Conservation Area Advisory Committee

Meeting Date : 6th April 2009

South Rear Elevation

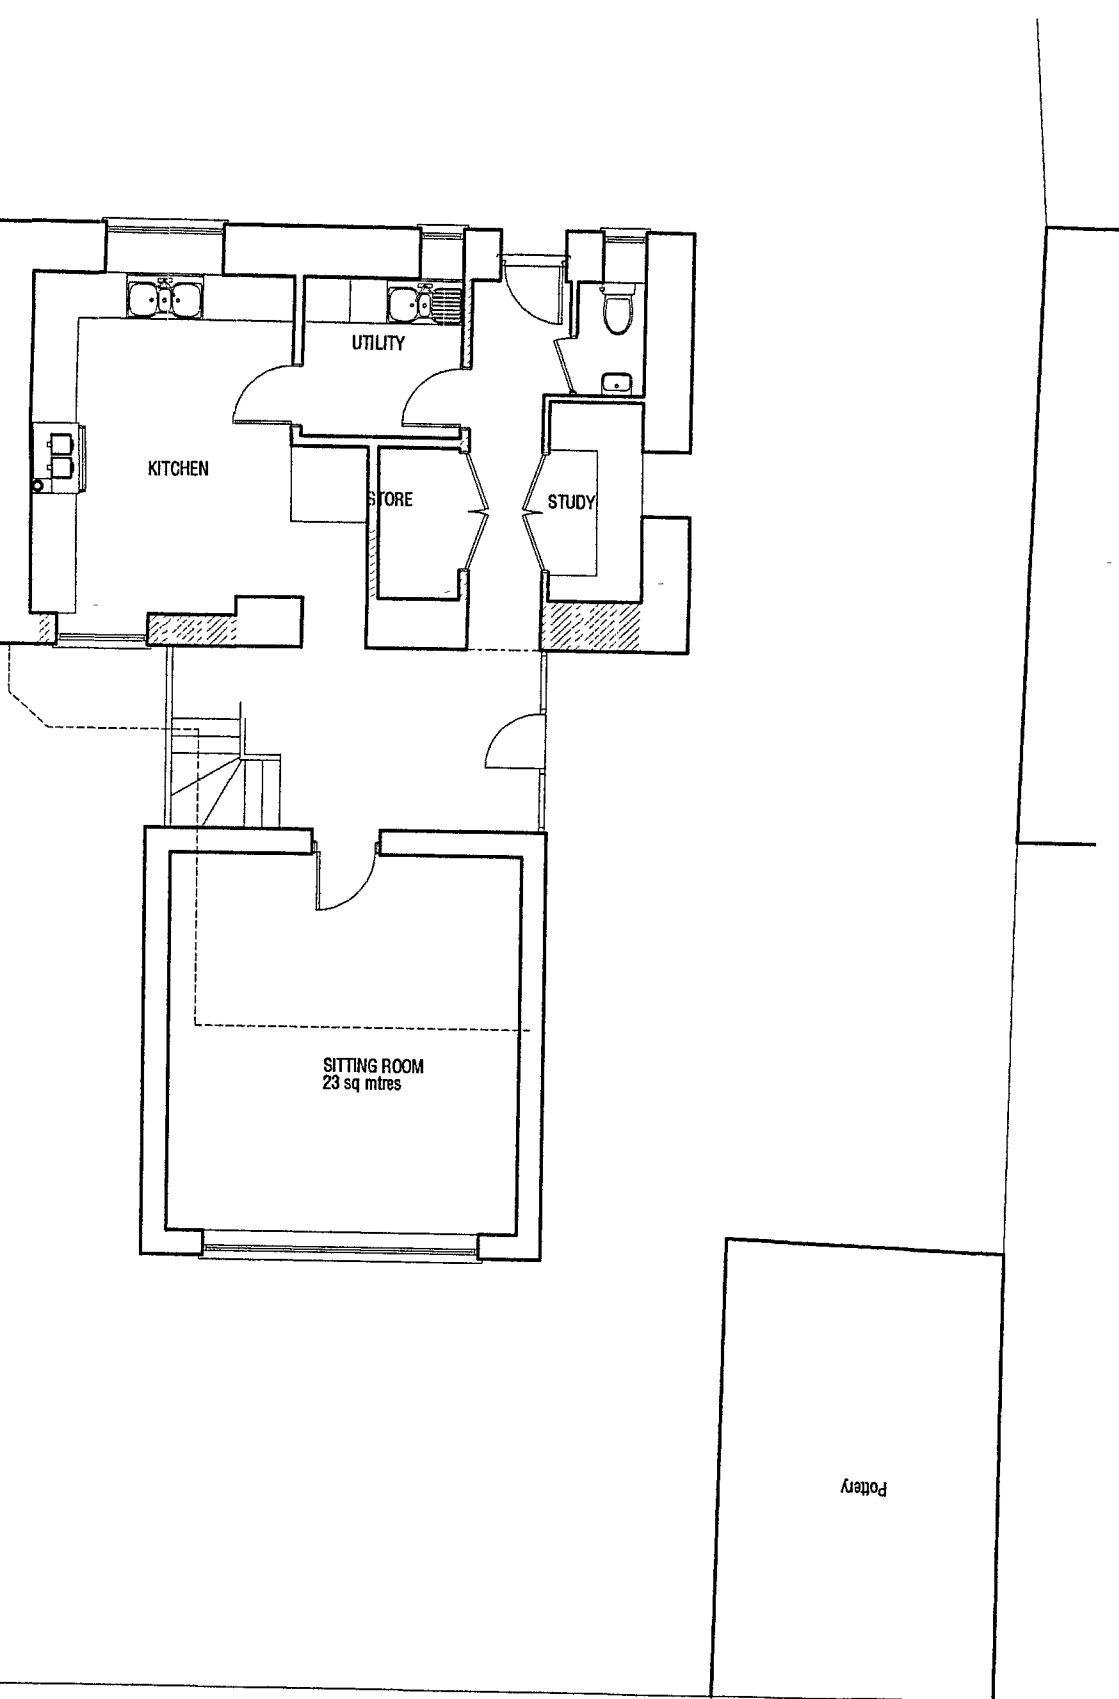
App No	Description/Address	Comment	Recommendation/Observation
<u>LY/5/09/</u>	Demolish existing garage and replace with oak framed garage, garden and domestic store. Church Field Church Lane Lyminster	NO Comment	
<u>R/33/09/L</u>	Application for Listed Building Consent for demolition of existing single storey rear extension, erection of new two storey rear extension to provide additional residential accommodation. The Coach House 81 The Street Rustington	Objection	It does not appear to meet the Inspector's comments that 'the extension should be visually subsidiary to the main build - up
